**KIRKLEES METROPOLITAN COUNCIL
INVESTMENT & REGENERATION SERVICE**

DELEGATED DECISION TO DETERMINE PLANNING APPLICATIONS

Reference No:	2024/62/91430/W
Site Address:	161-165, Lane Top, Royd House Lane, Linthwaite, Huddersfield, HD7 5SG
Description:	Erection of single and two storey extension and alterations to dwelling including rebuilding of external wall. Demolition of former garage and erection of detached home office with hobbies room (within a Conservation Area)
Recommending Officer:	Joanna Rednall

DECISION – CONDITIONAL FULL PERMISSION

east elevation

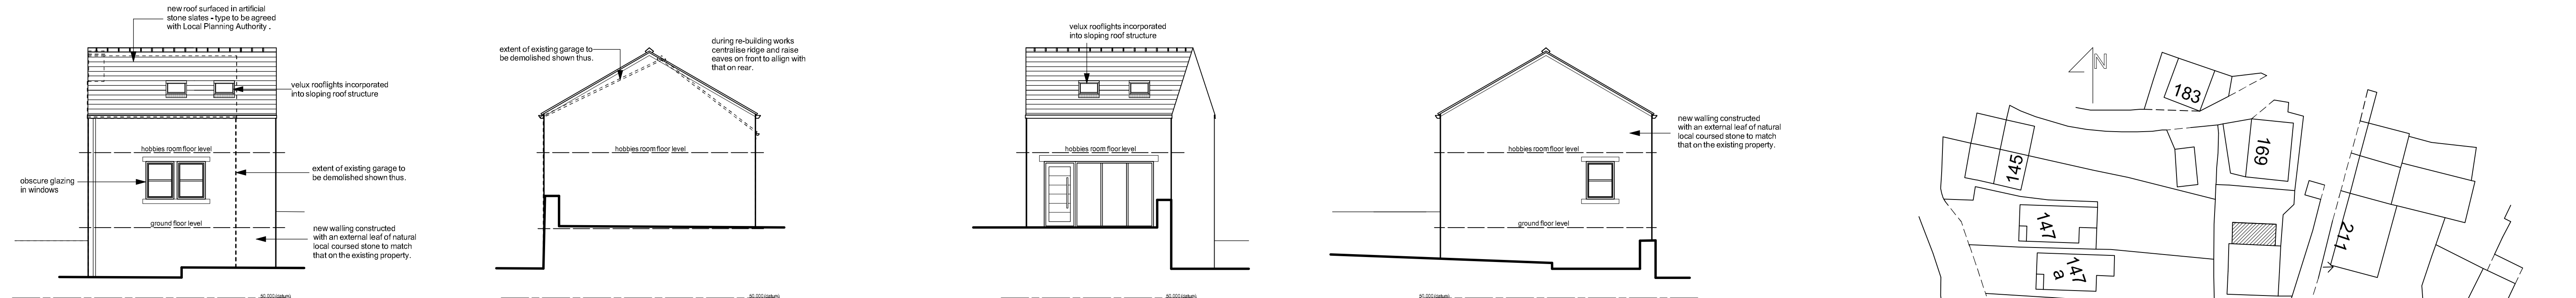
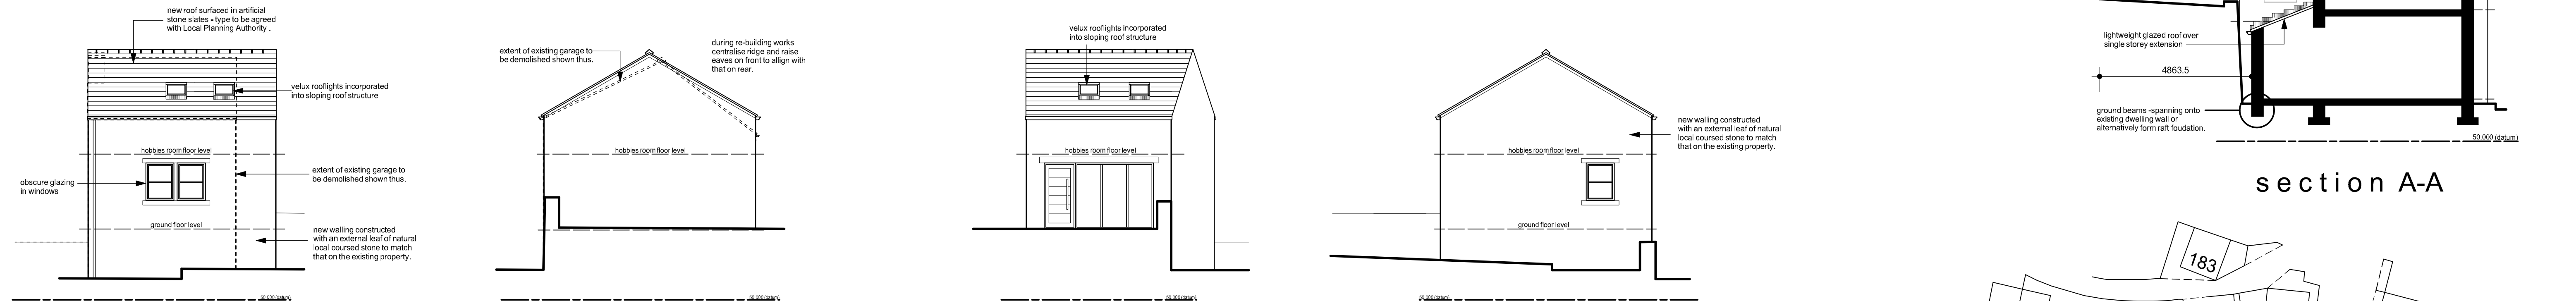
The Conservation and Design officer consulted for this application stated initial concerns with the rooflights proposed to the east-facing elevation, given the proximity of this alteration to the adjoining highway. The applicant's agent successfully amended the scheme in response to these comments, as such the Conservation officer raised no objections to the proposed works.

Minor amendments were made to the proposed elevations following comments from KC Conservation and Design. This consisted of removing 2 rooflights on east elevation on the main dwelling. In addition, discussions were held with the applicant's agent following the consultation response from KC Highway Structures. The applicant's agent submitted revised plans that were deemed acceptable and used in the determination of this application.

facing elevation of the outbuilding that would overlook the rear amenity space of this neighbour. The submitted plans confirm these windows will be obscure glazed. As such, a condition to secure obscure glazing is recommended to protect the privacy of these and future neighbours' amenity (Condition 4).

4. The development shall not be occupied until the windows in the western elevation of the detached outbuilding hereby approved have been obscure glazed minimum grade 4. The obscure glazing shall thereafter be retained for the lifetime of the development.

site plan 1/500

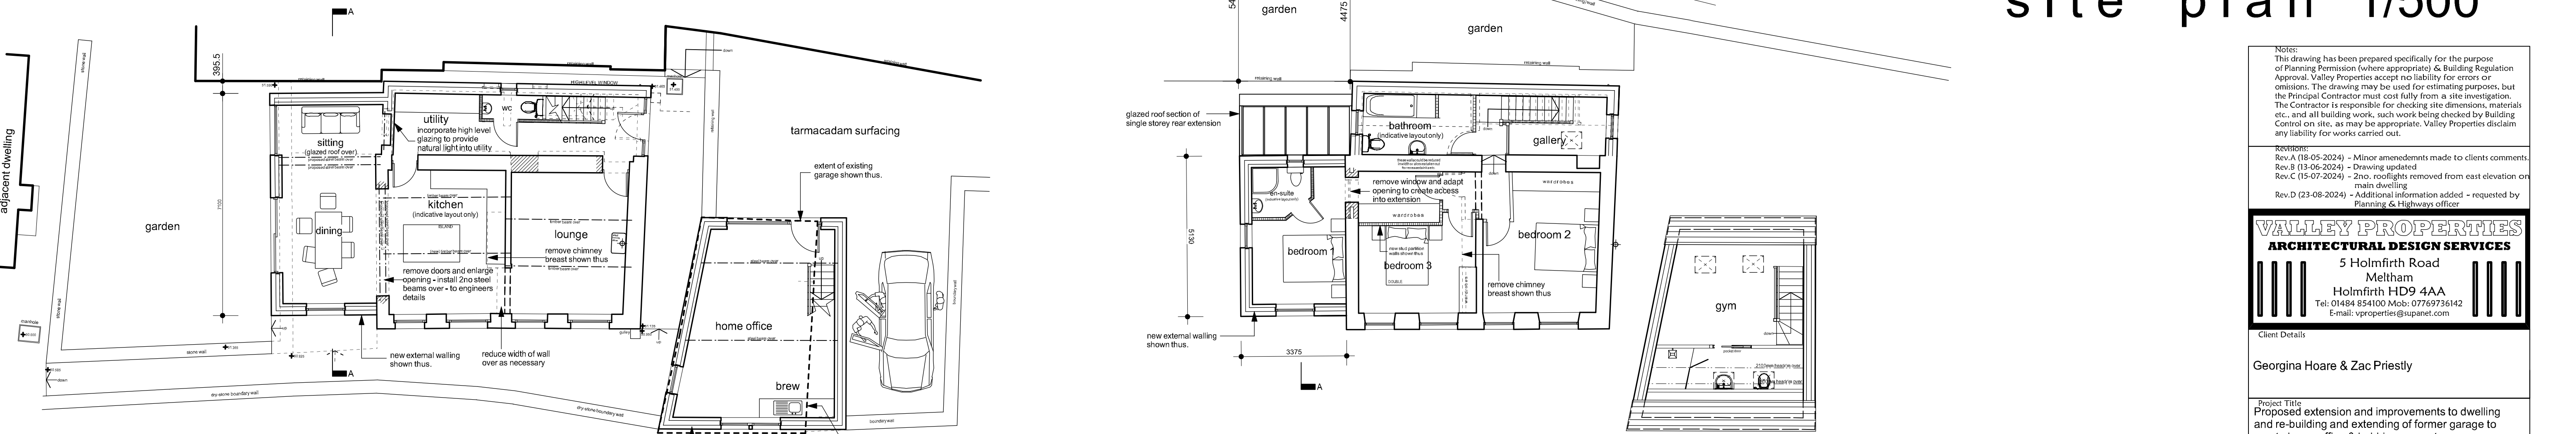
Given the proximity of the development to the retaining structure (burr wall) supporting Tommy Lane, Highway Structures were consulted on the application. Policy LP53 of the Local Plan states that 'for development identified at being at risk of instability....measures should be incorporated to...ensure...[this] does not have the potential to cause harm to people or the environment. Chapter 15 of the NPPF also considers with impact of instability. Highway Structures initially recommended conditions to ensure that the development is carried out safely with regard to the highway retaining structure that marks the boundary of curtilage of the application site. Following receipt of additional plans and further information from the applicant's agent, Highway Structures have confirmed a condition is not required as the proposed development is not considered to have any impact on the highway.
